## Able UK Ltd

Your Ref: AN/2012/113982/01-L12

Date: 21<sup>st</sup> November 2012

### **RESPONSES TO EA LETTER OF 9<sup>TH</sup> NOVEMBER 2012**

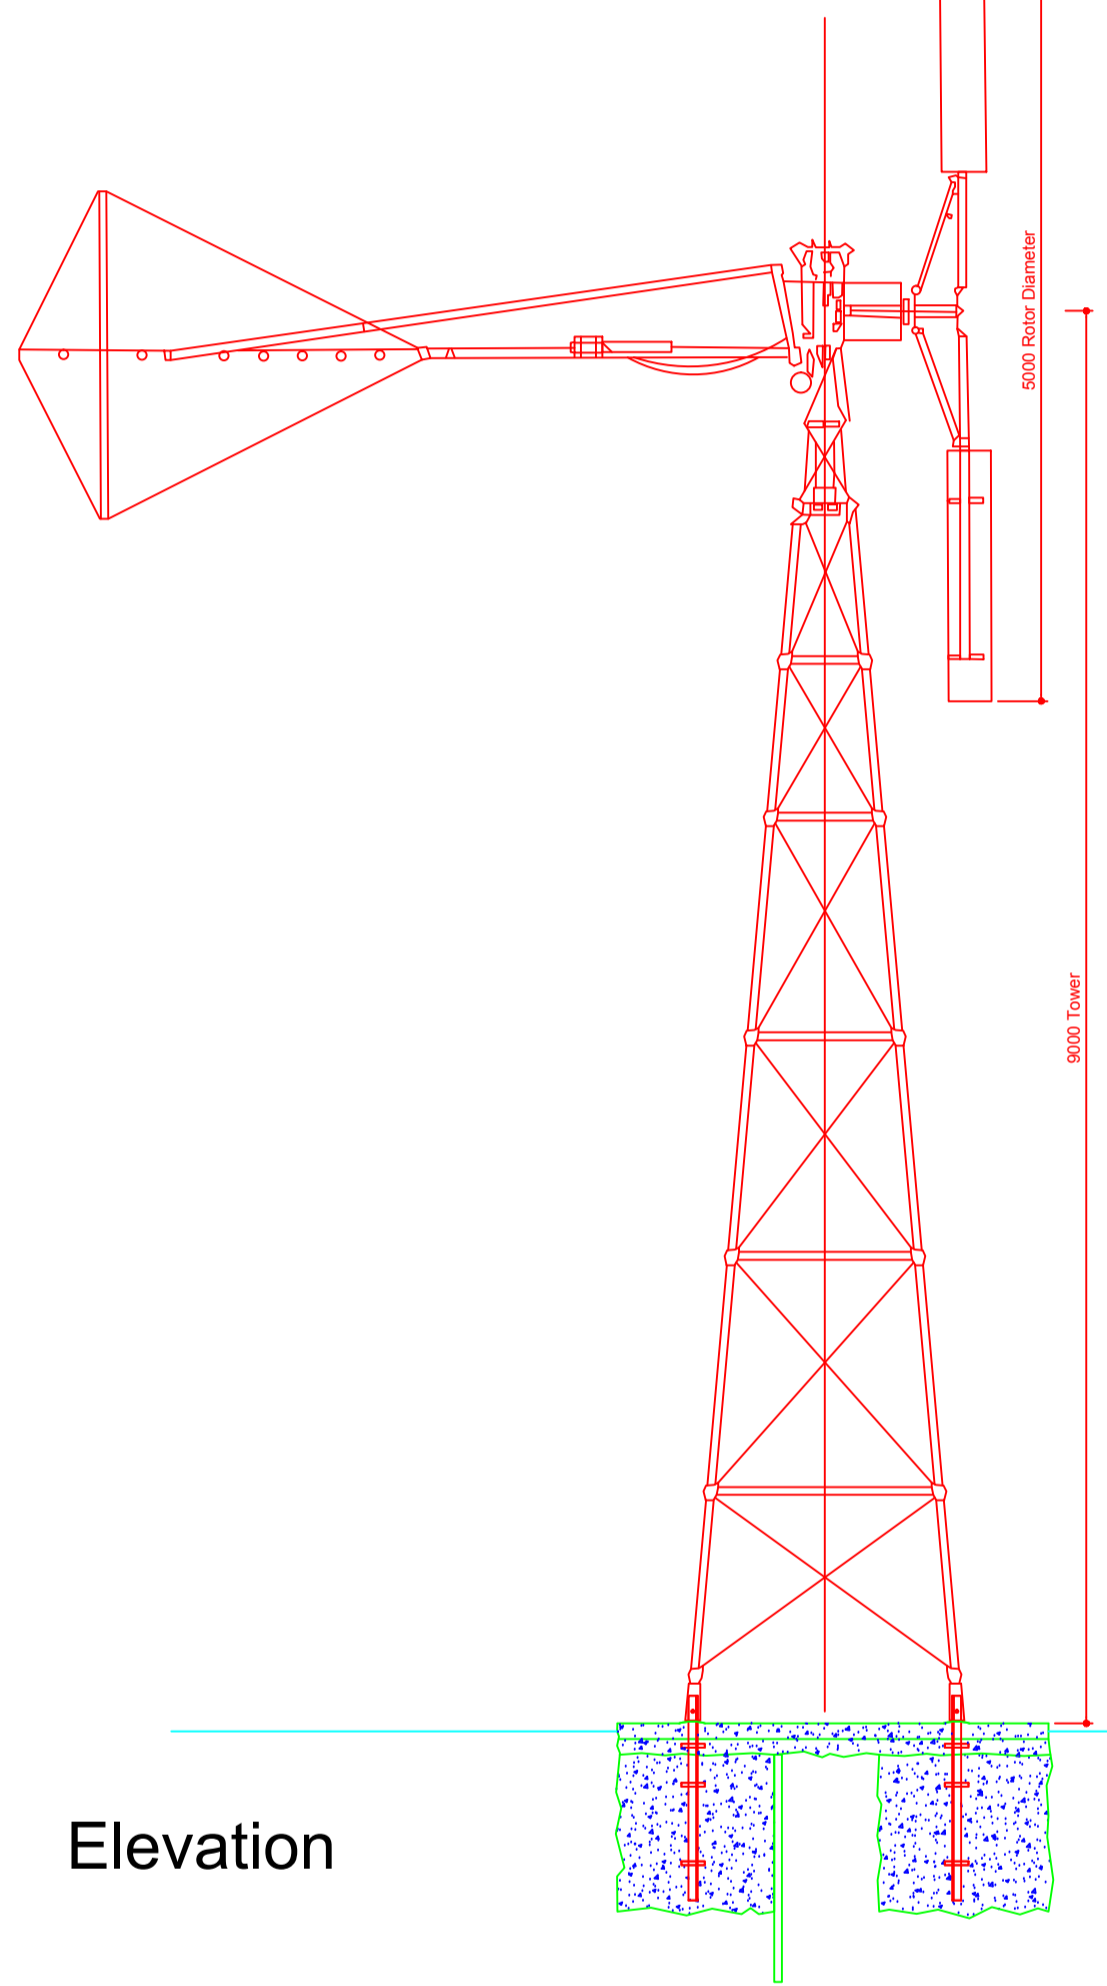
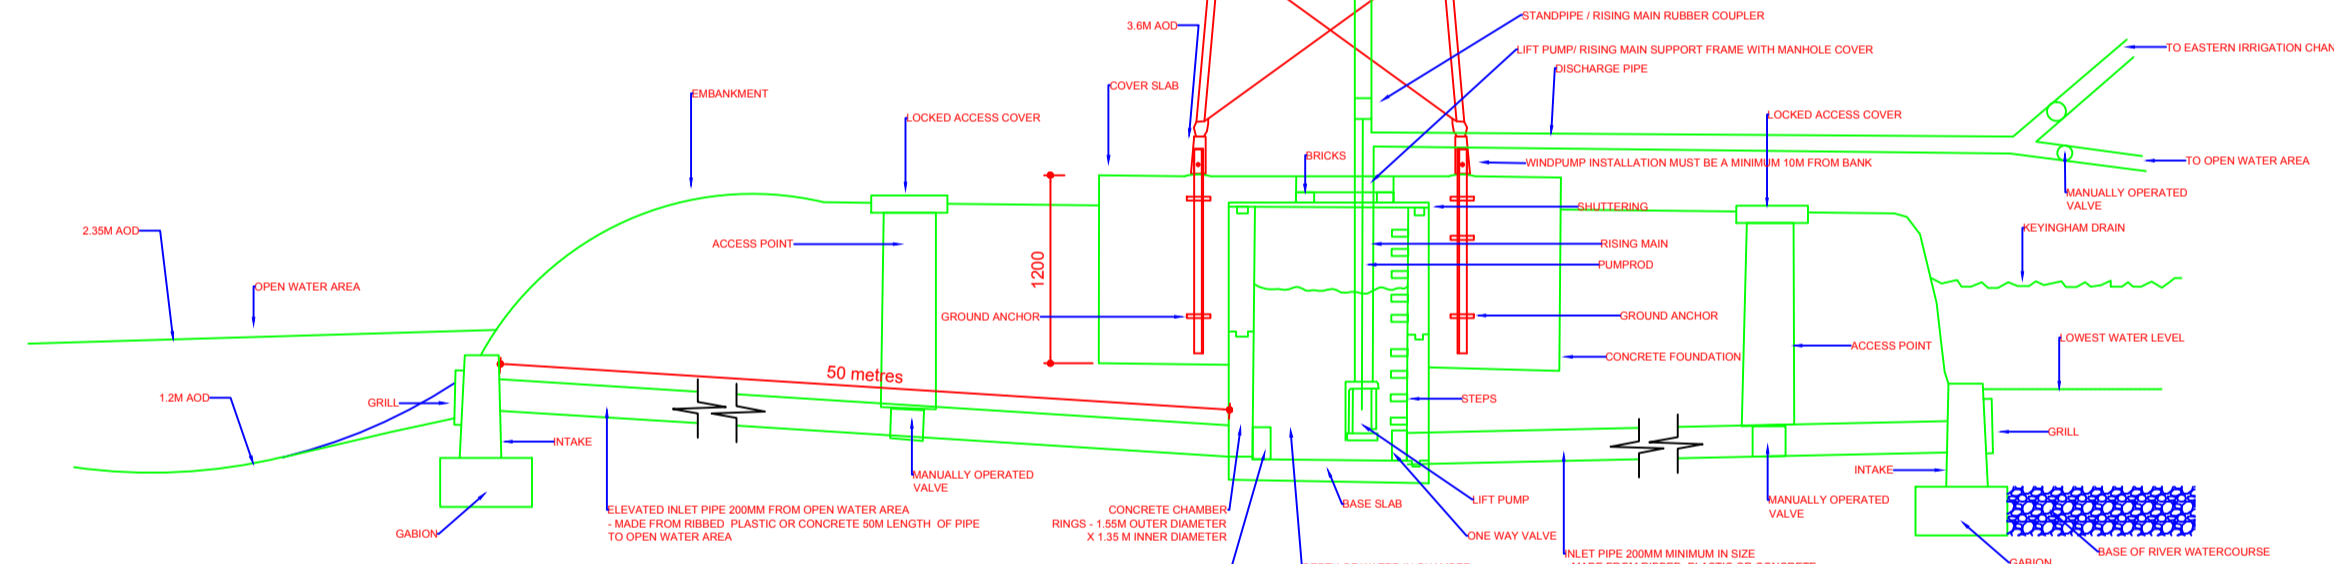
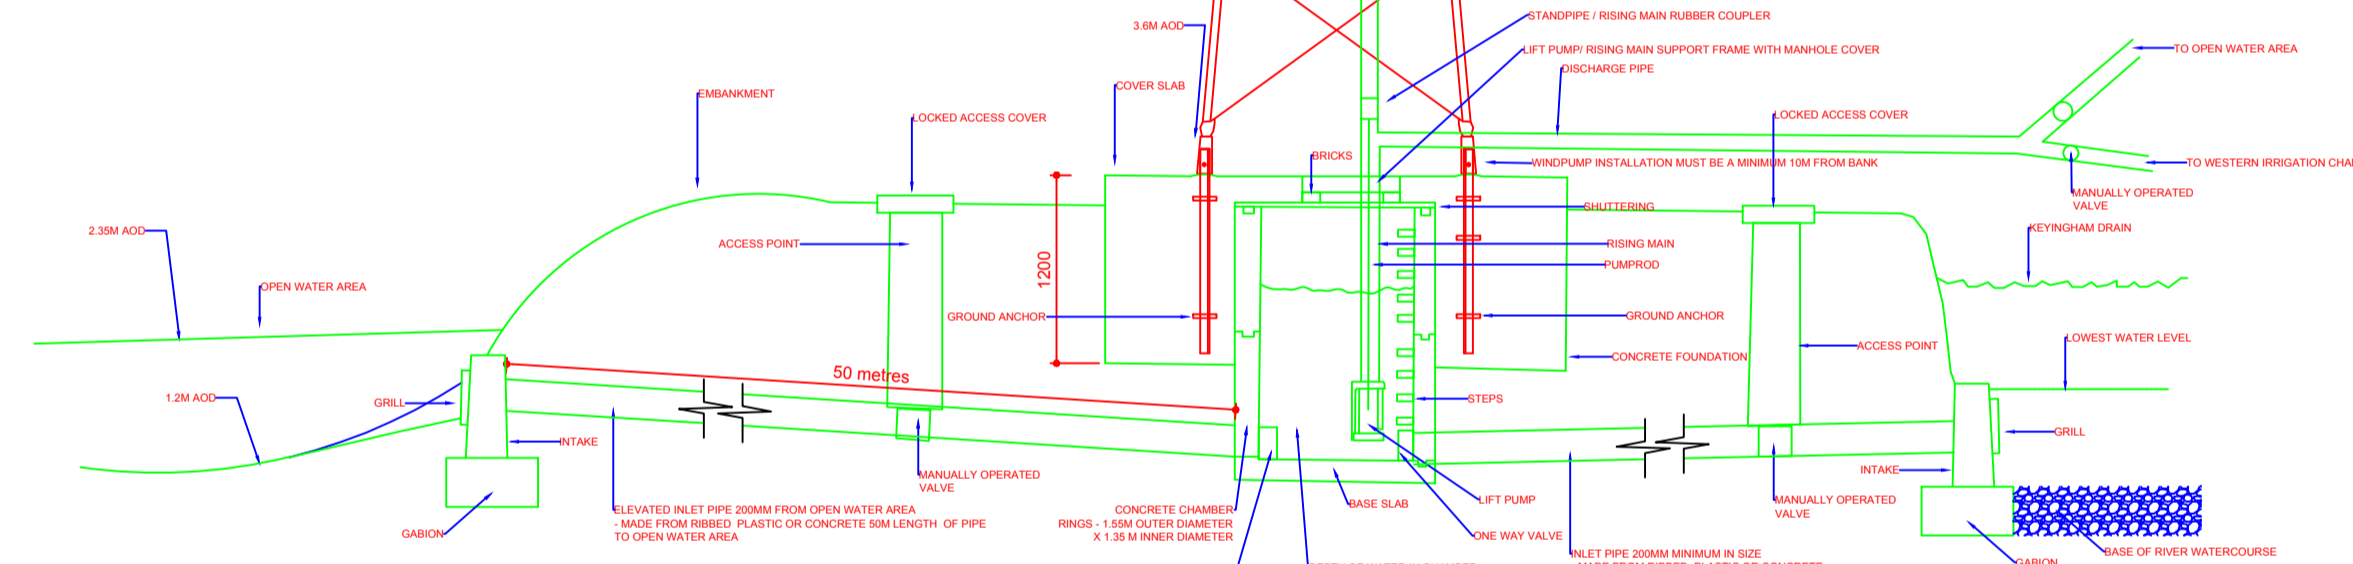
6.1 In para 6.2.31 of EX28.3, Part 4 it is stated that the two wind powered pumps will each be 5m in diameter and stand 8-10m in height and have an output of 5m head.

- 11.1 The wind pumps are shown in Figure 3 of EX28.3: Part 4. They are not located on the flood defence embankment but on a small bund around the perimeter of the wet grassland.
